**Subject:** R-6 Small Infill Design Review – 107 Monument Street

**Written by:** Caitlin Cameron, Urban Designer

**Date of Review:** Friday, August 7, 2015

A2.1

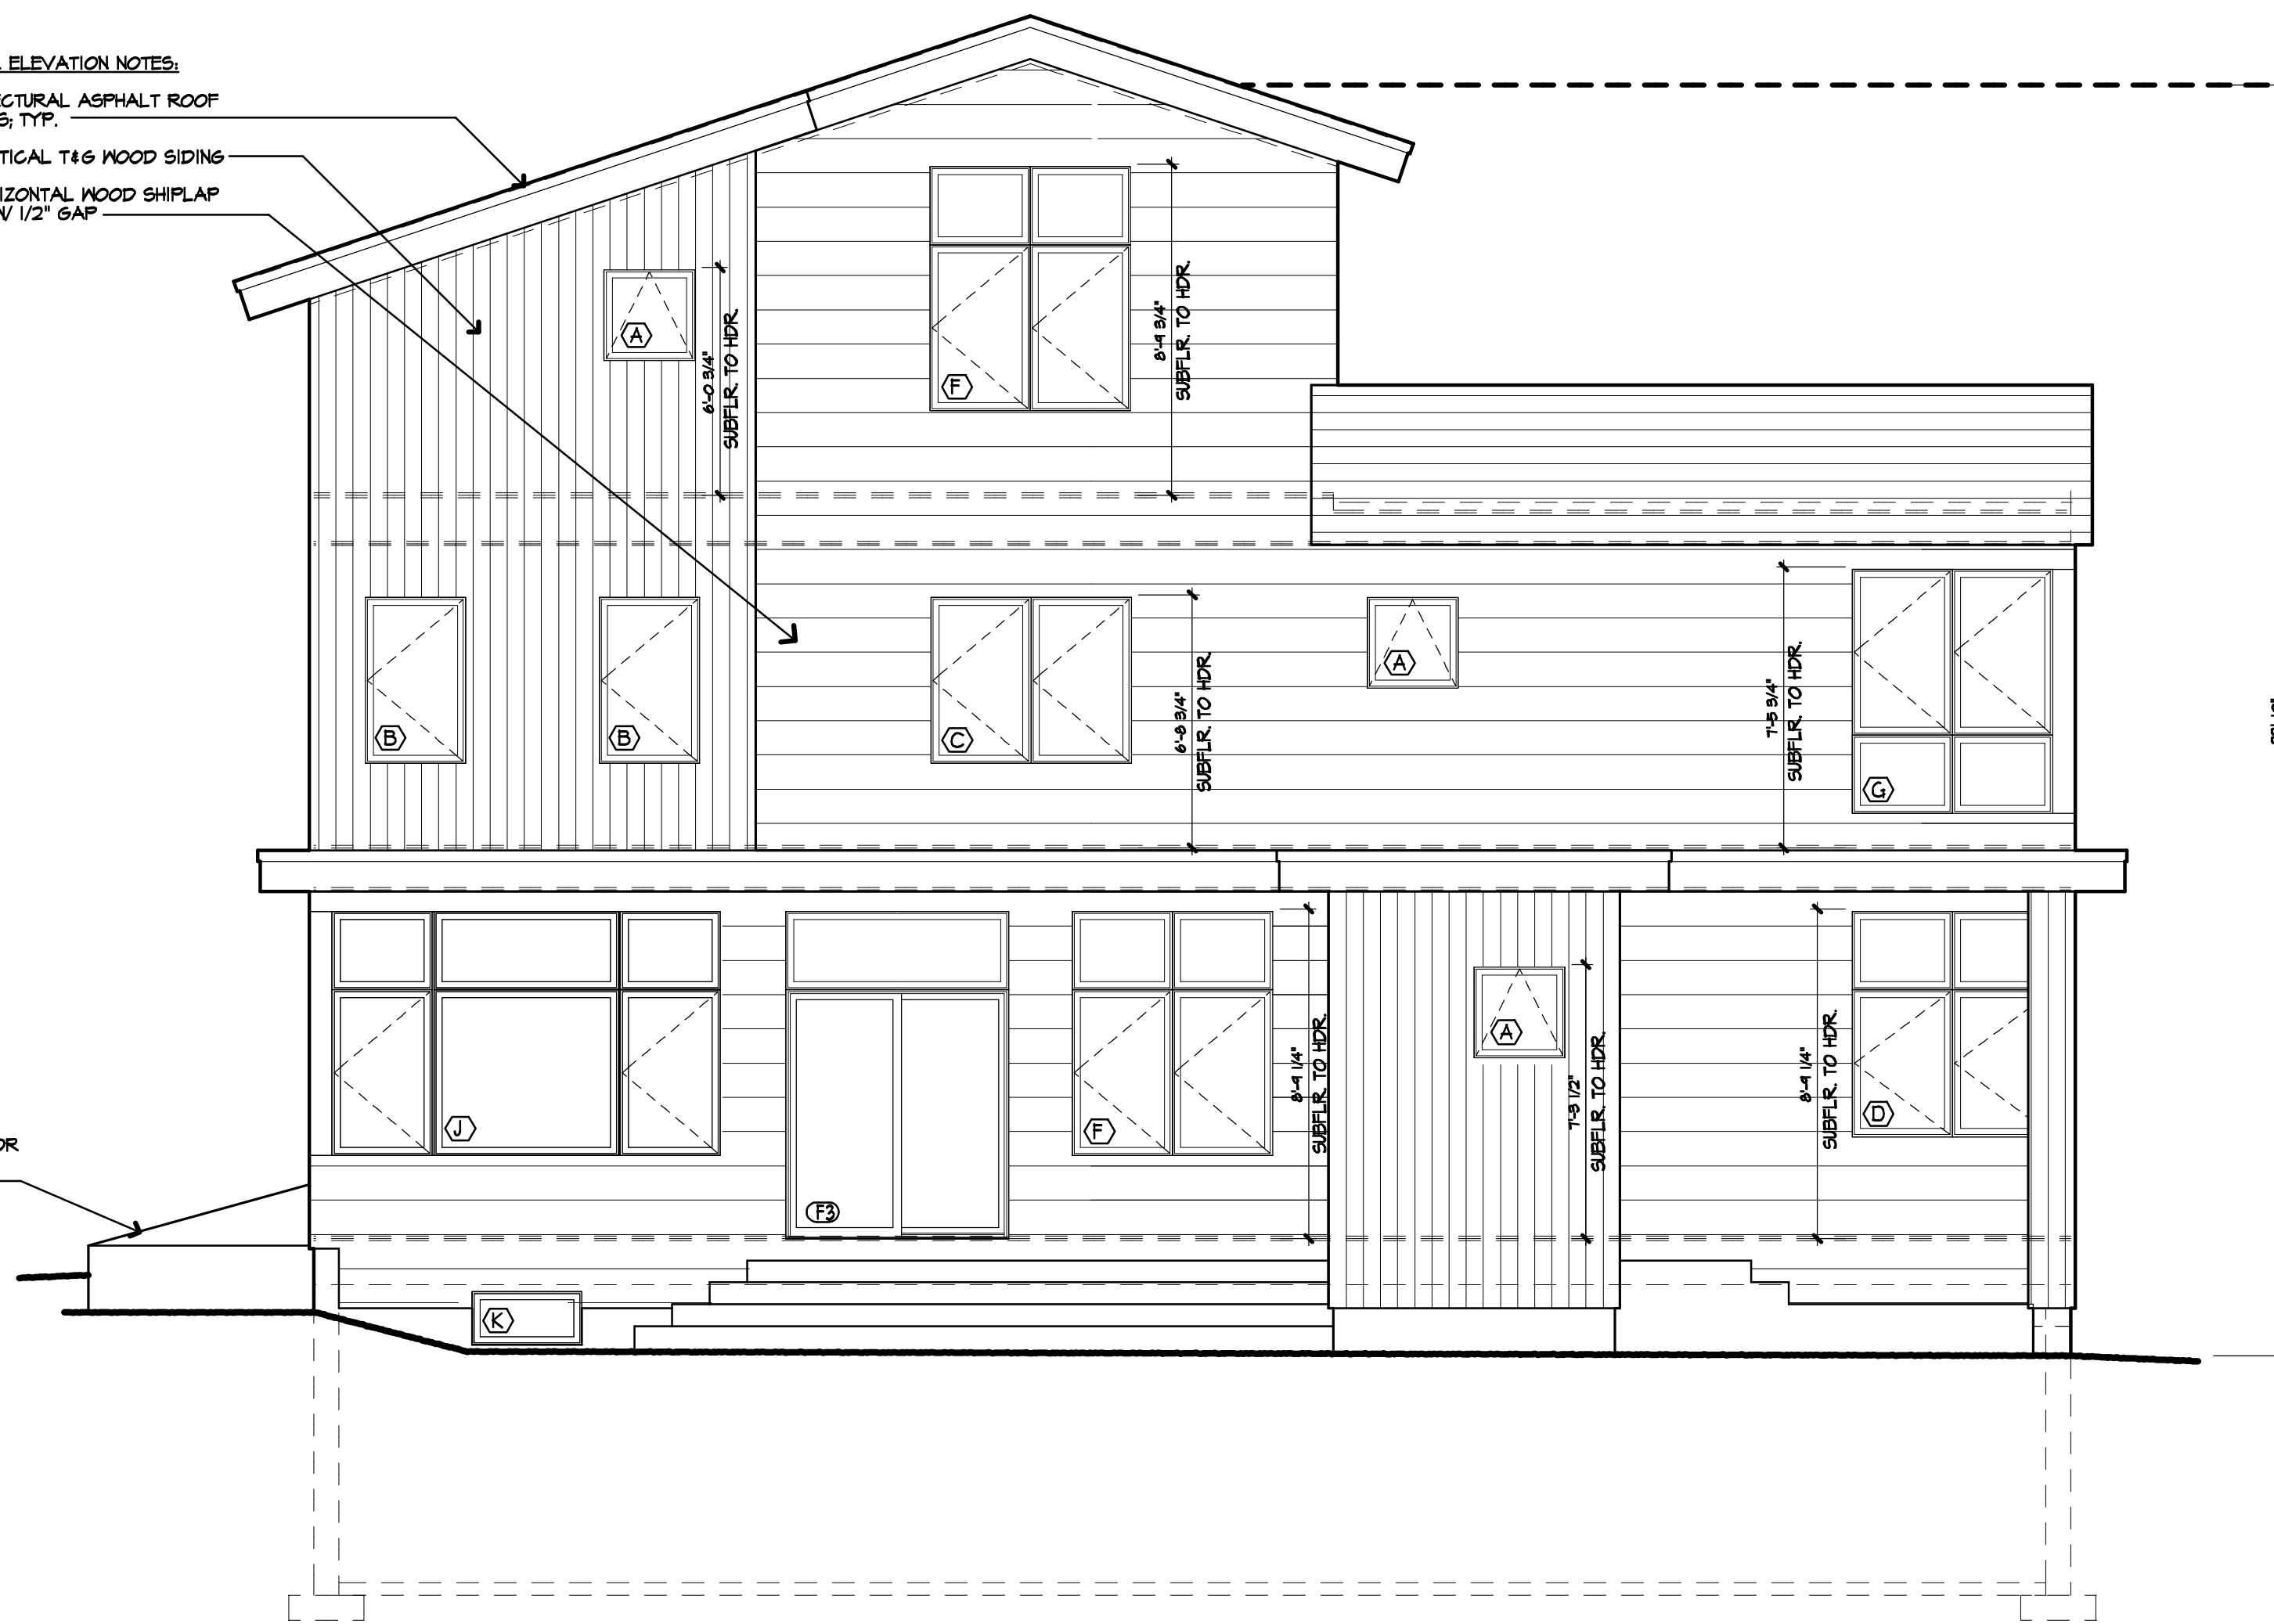
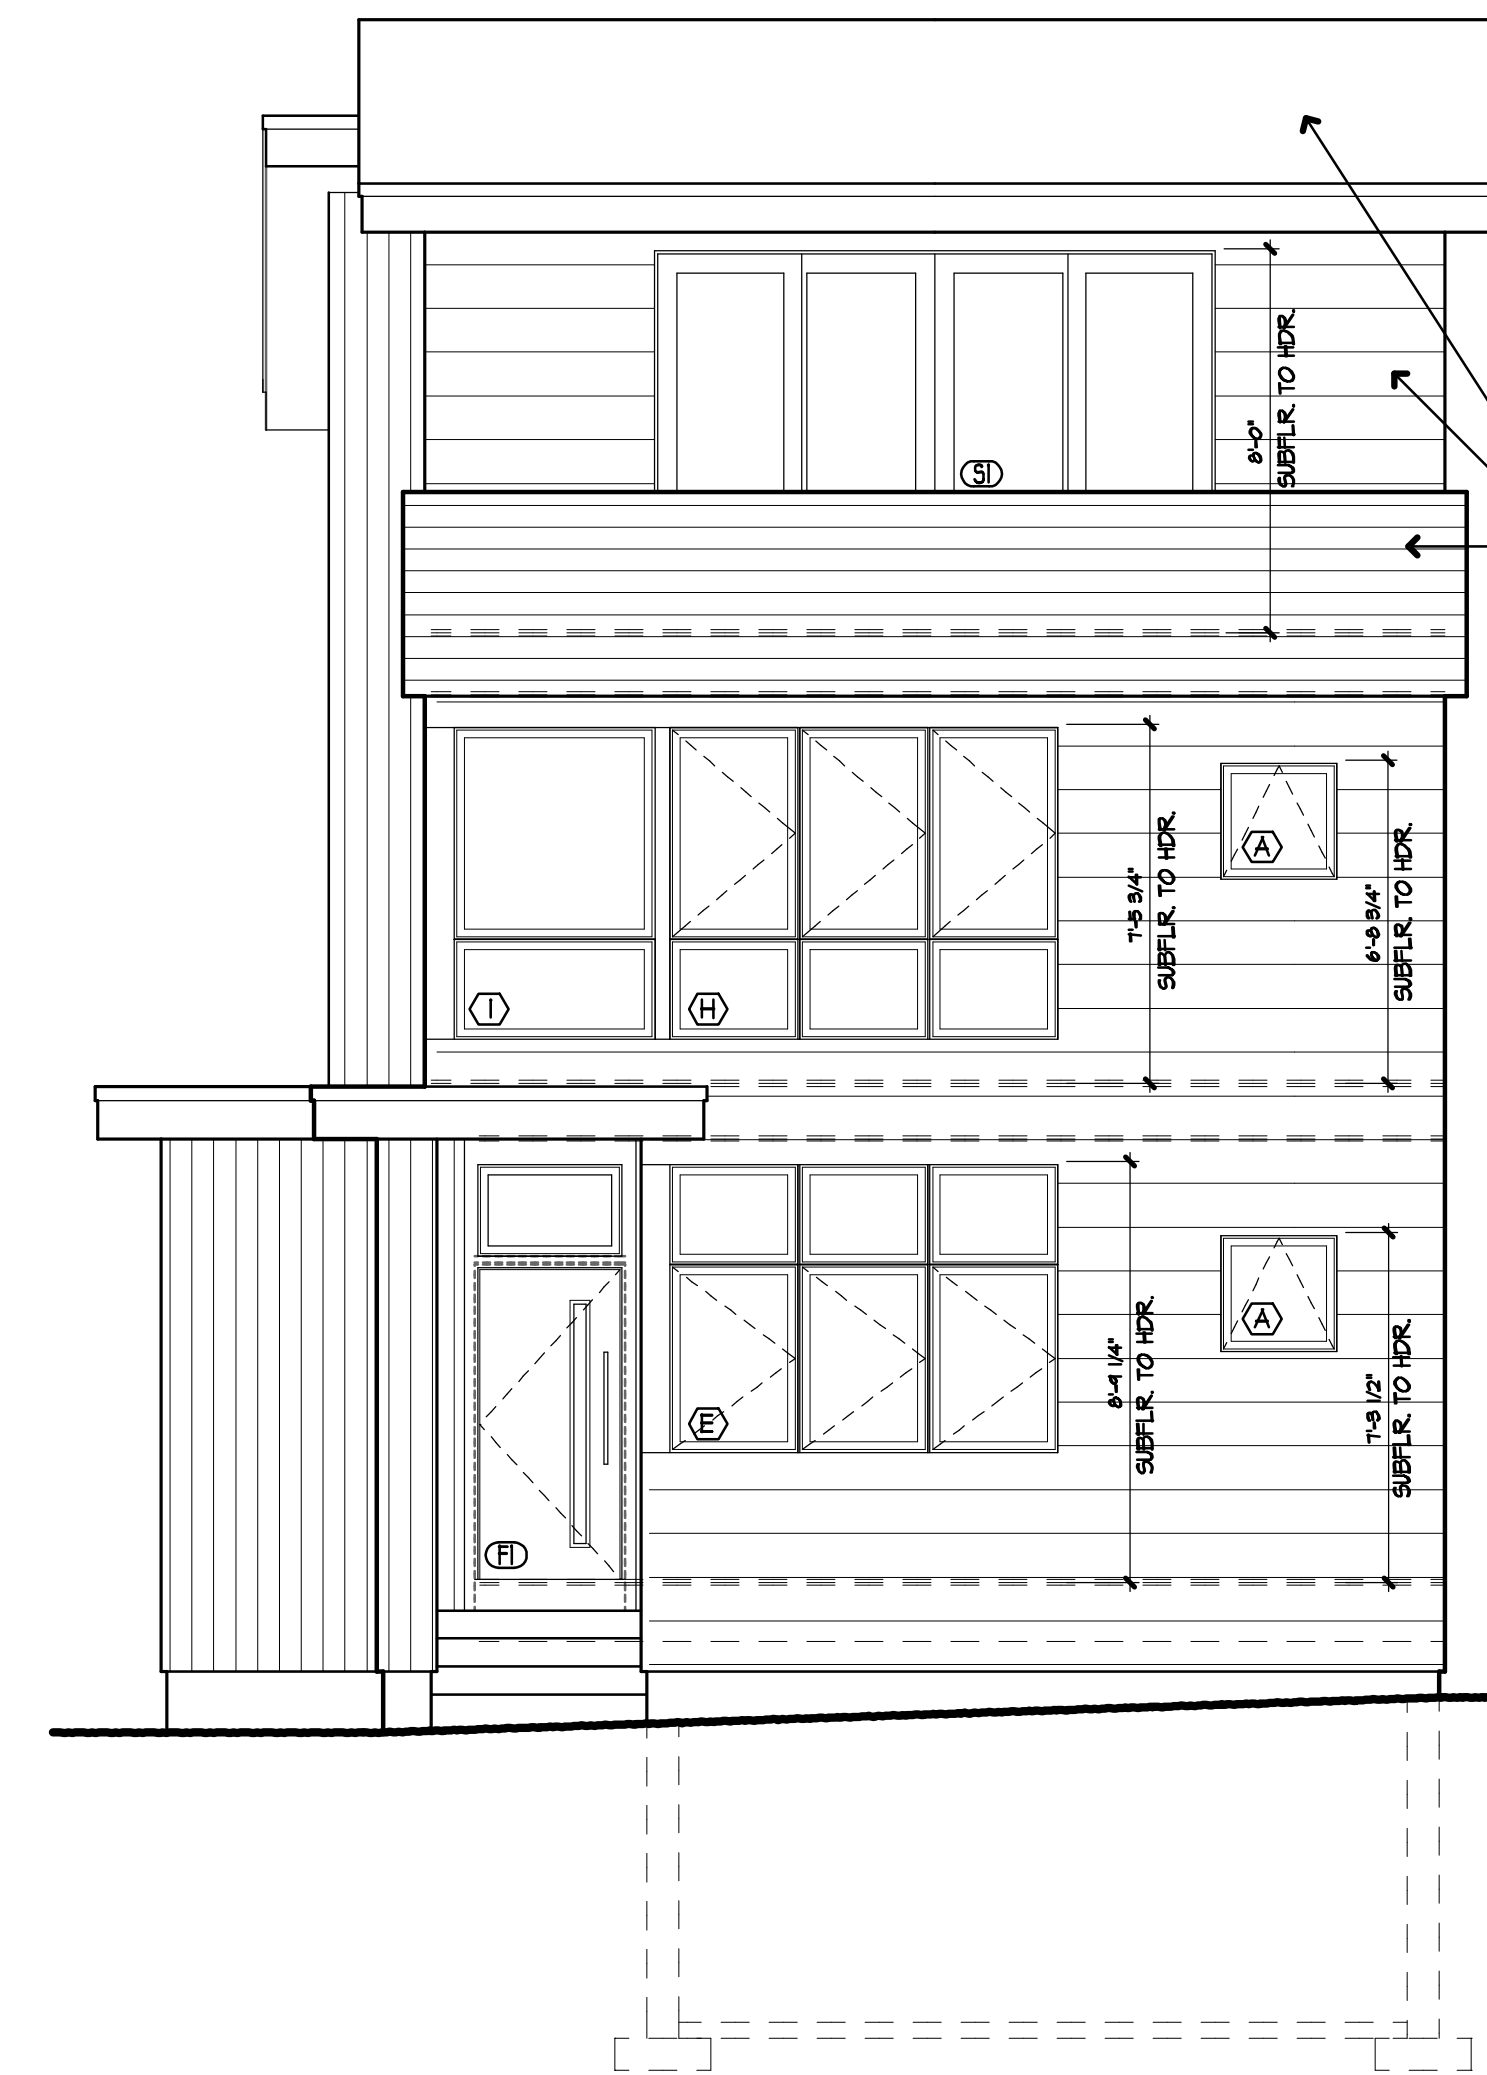
*Principle A Overall Context* – Met – the scale and height of the proposal is consistent and compatible with the surrounding residential context. The form is more contemporary with an asymmetrical roof but building form, proportion, and orientation are similar to the residential context. The two-story front portion of the building sits proud at the street with the taller, contemporary roof line setback, therefore mitigating the visual impact.

- *A-1 Scale and Form*: The scale of the project is in keeping with the existing context. The form of the roof shape is not typically found with the predominant character-defining architectural features of the neighborhood but is set back from the street so as to be recessive.

- *A-2 Composition of Principal Facades:* The front façade composition is contemporary but retains similar characteristics, proportion, size, fenestration patterns, and orientation to the surrounding context.
- *A-3 Relationship to the Street:* The building has a similar orientation and placement to the street as the house being replaced. The front façade is right at the property line creating a street wall consistent with the block and the front entry is oriented to the street/sidewalk.

- *B-1 Massing:* The proposed mass is harmonious with the massing of the existing buildings in a two block radius.
- *B-2 Roof Forms:* The proposed roof form does not refer to the architectural forms found within a two-block radius which are predominantly front-end gable and flat roofs.
- *B-3 Main Roofs and Subsidiary Roofs:* Met – there is a clear main roof form.
- *B-4 Roof Pitch:* The standard requires that gable roofs shall be symmetrical and have a pitch between 7:12 and 12:12. The roof pitch was not provided but looks to be less than 7:12.
- *B-5 Façade Articulation:* The project employs three (two required) of the required architectural elements: a balcony, a recessed entry, and a covered porch.
- *B-6 Garages:* Not applicable

- *D-1 Windows:* The majority of windows are rectangular and vertically proportioned.
- *D-2 Fenestration:* The applicant did not provide dimensions to verify the 12% fenestration requirement. However, in a rough estimate, the standard appears to be met. Windows and doors are appropriately scaled to the building.
- *D-3 Porches:* Not applicable

- *E-1 Window and Door Height:* The majority of window and door head heights align along a common horizontal datum.
- *E-2 Window and Door Alignment:* The majority of windows shall stack so that centerlines of windows are in vertical alignment.
- *E-3 Symmetry:* Primary window compositions are arranged symmetrically around discernable vertical axes.

- *F-1 Articulation:* It is a little bit difficult to discern the trim and window details of the project however, if there is a little bit of a shadow line created with these details, as it appears there would be, then the standard is met.

- *F-2 Window Types:* The project uses more than two window types.
- *F-3 Visual Cohesion:* The change in material contributes to the façade composition and overall remains cohesive. However, the material choice itself is problematic (See comments below regarding materials).

*Principle G Materials – Met – The material palette was modified to be harmonious with the character defining materials of the neighborhood. The parapet wall at the front of the building uses a material that is consistent with the neighborhood but is designed in a way that is different from the predominant architectural forms. After a conversation with the architect, staff determined, though not ideal, this parapet configuration was acceptable given the desires of the homeowner for privacy.*

- *G-1 Materials:* The material palette was modified to be consistent with the predominant residential character of the neighborhood in scale, texture, and visual interest of a smaller-scale material choice while keeping a contemporary application.
- *G-2 Material and Façade Design:* The materials are appropriately placed according to their nature. The exception is the use of clapboard on the parapet/balcony edge at the front of the house. A lighter material, such as a rail is still preferred. The use of shingles, a solid wall, and a rectilinear line creates a heavy form at the roof lines of the two-story mass inconsistent with the surrounding neighborhood.
- *G-3 Chimneys:* Chimney not indicated on elevation drawings. Presumed to be metal.
- *G-4 Window Types:* More than two window types are used.
- *G-5 Patios and Plazas:* Not applicable
